A47/A11 Thickthorn Junction

9.25 Applicant's Responses to Submissions at Deadline 7

**9.25 APPLICANT'S RESPONSES TO SUBMISSIONS
AT DEADLINE 7**

Rule Number:	8(1)(c)
Planning Inspectorate Scheme Reference	TR010037
Application Document Reference	TR010037/EXAM/9.25
BIM Document Reference	HE551492-GTY-LSI-000-RP-ZL-40801
Author:	A47/A11 Thickthorn Junction Project Team, Highways England

DRAWING NUMBER
HE551492-GTY-LSI-000-DR-CH-31003

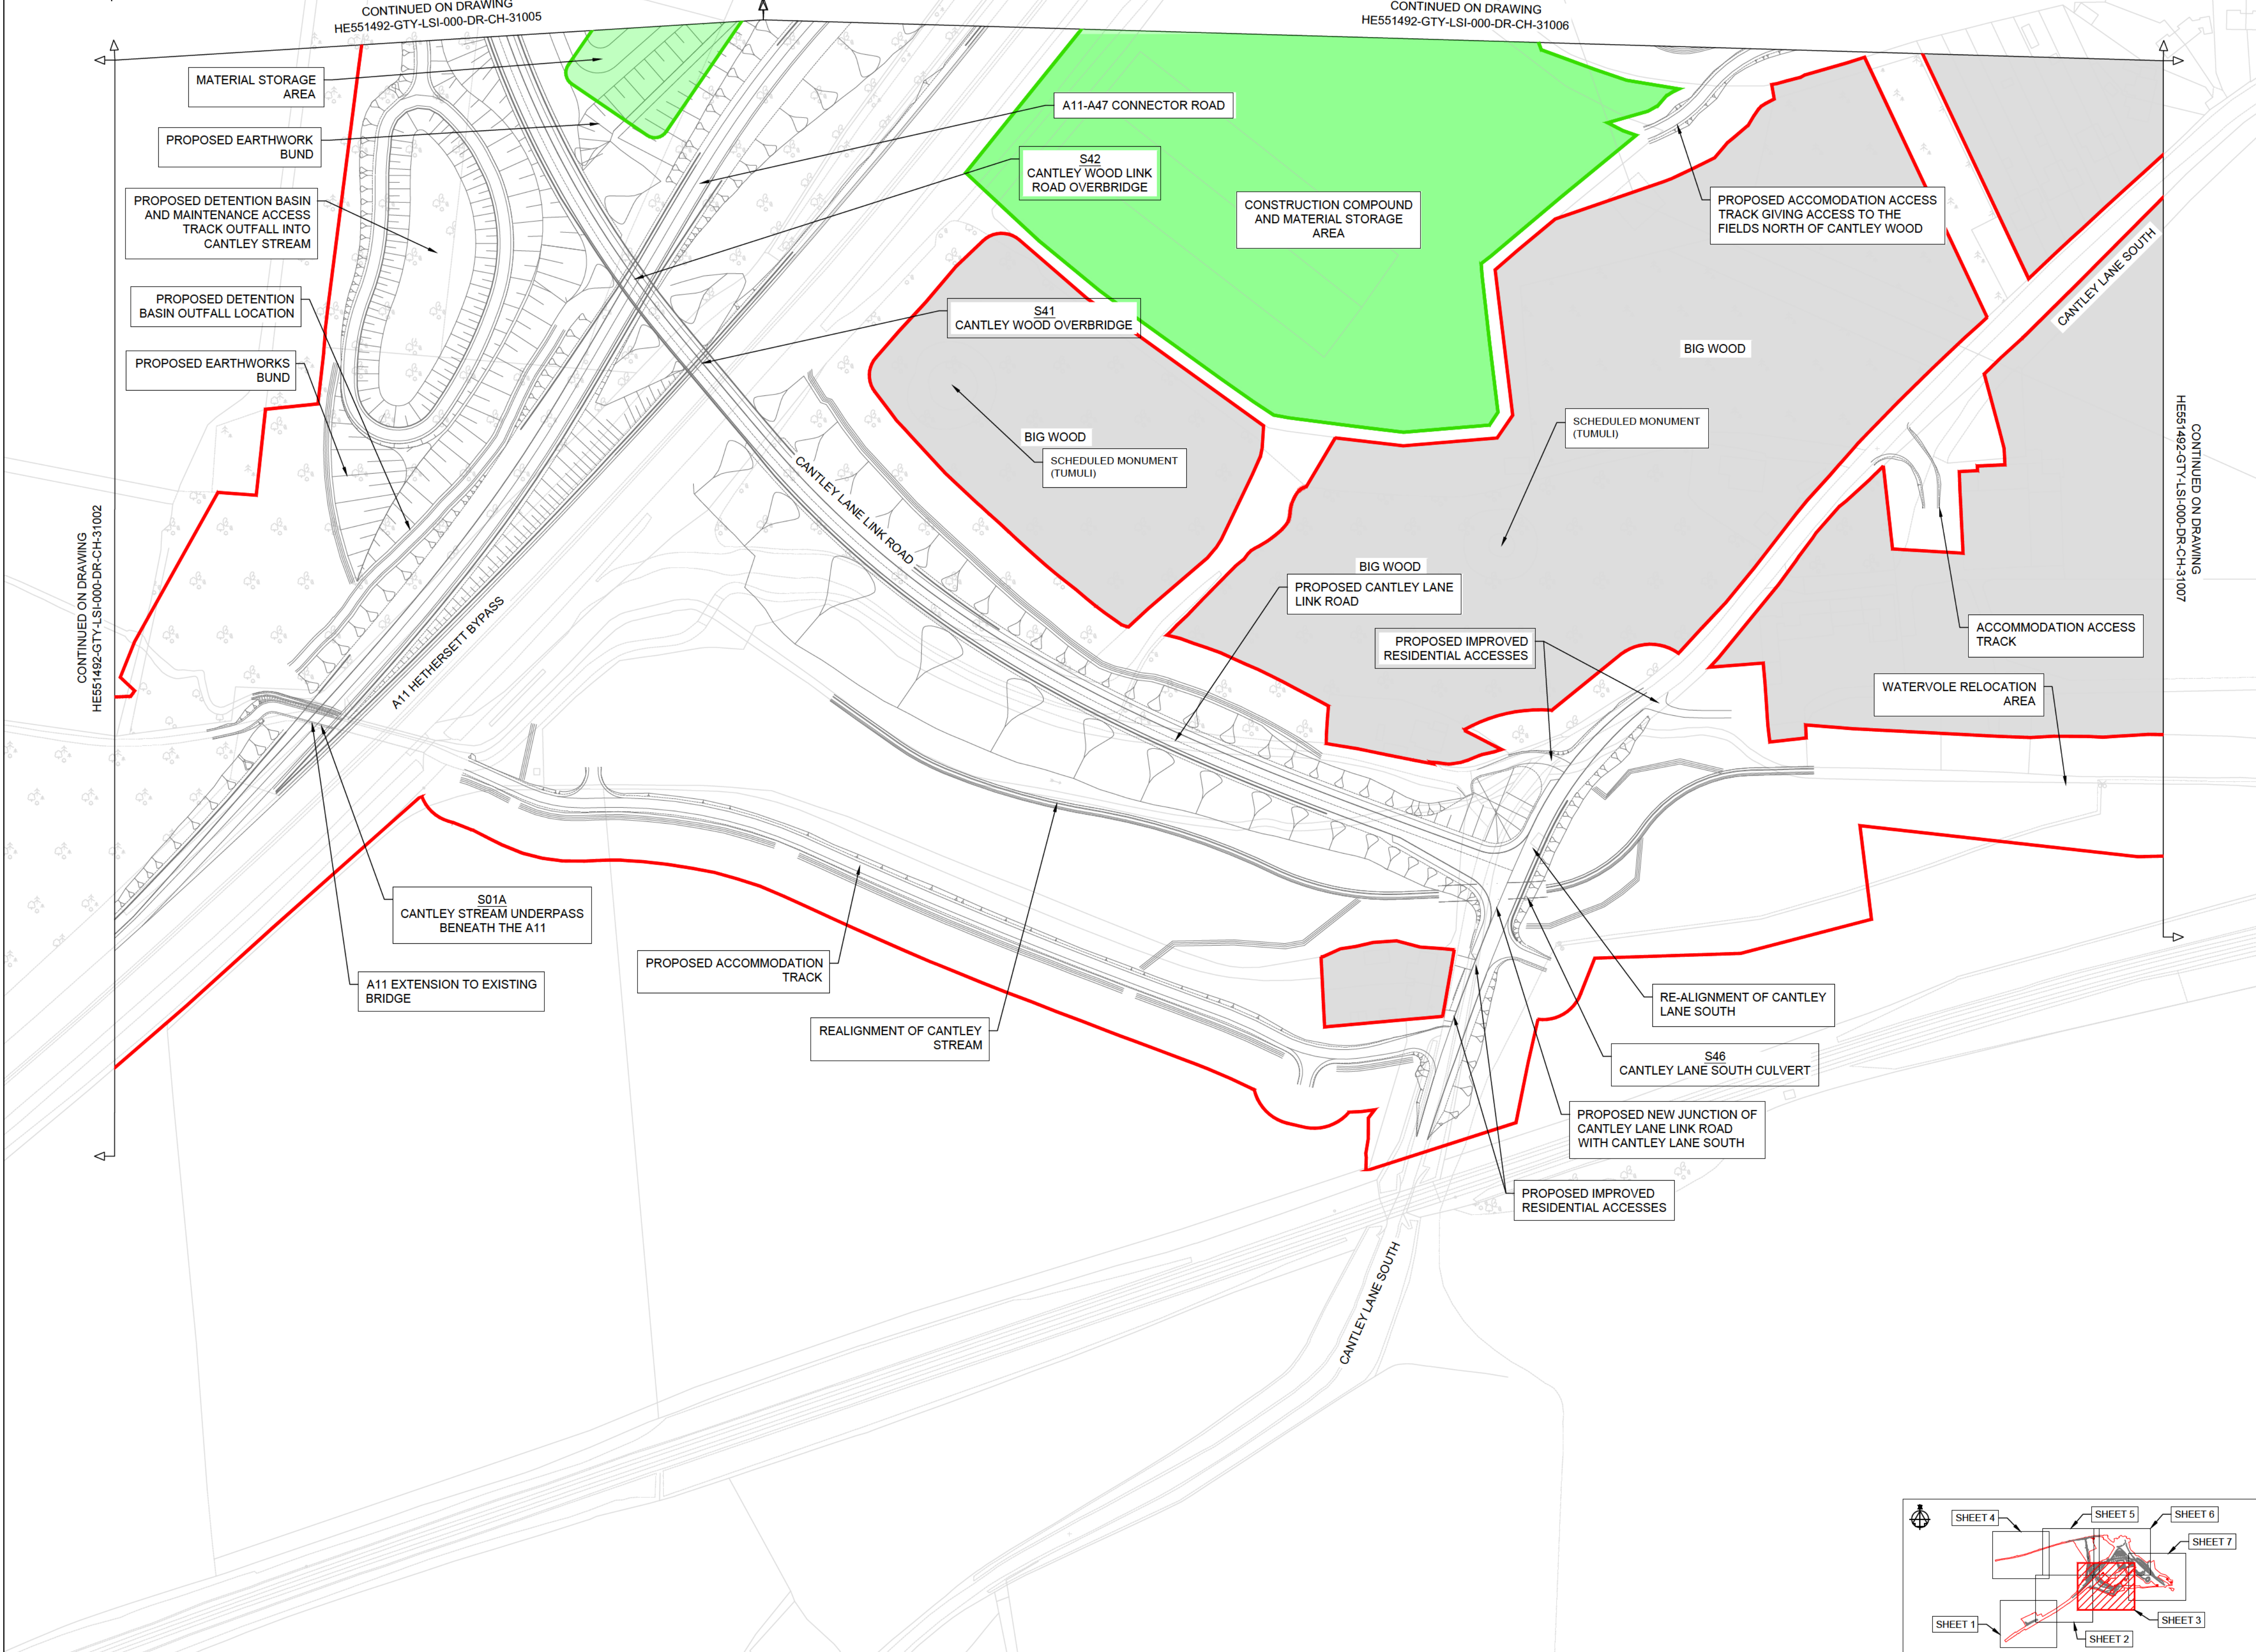
6	Of fundamental importance to my client is the specification and future ownership and access rights over the proposed accommodation track, shown on drawings HE551492-GTY-LSI-000-DR-CH-31003 and HE551492-GTY-LSI-000DR-CH-31006, enclosed. My client is losing their existing access to the fields north of Cantley Wood as a consequence of this project, this being an access and track over which they have complete control and security, and across which two vehicles can pass side by side. We realise there may be no alternative route for the proposed accommodation track than the long one proposed and that Highways England will need to retain some rights of access and maintenance over it in the future. That being accepted, where possible my client should not be left in worse position after the project than before it and thus should be granted ownership of the new track without any restrictions on their use of it, and it should be the case that the new route is properly secured and capable of accommodating two cars side by side. We await confirmation that these requirements are being facilitated.	<p>As noted in the response to Relevant Rep RR-012.18 (REP1-004) the current width of the proposed access track is 3.5m which the Applicant deems appropriate for the intended use of the track.</p> <p>The Applicant has already committed to engage with the respondent during the detailed design stage to provide appropriately spaced passing places.</p> <p>Since this track crosses third party land ownership of the new track without any restrictions on use of it cannot be offered, however, permanent rights of access will be granted to the respondent when the land is returned to the existing landowner.</p>
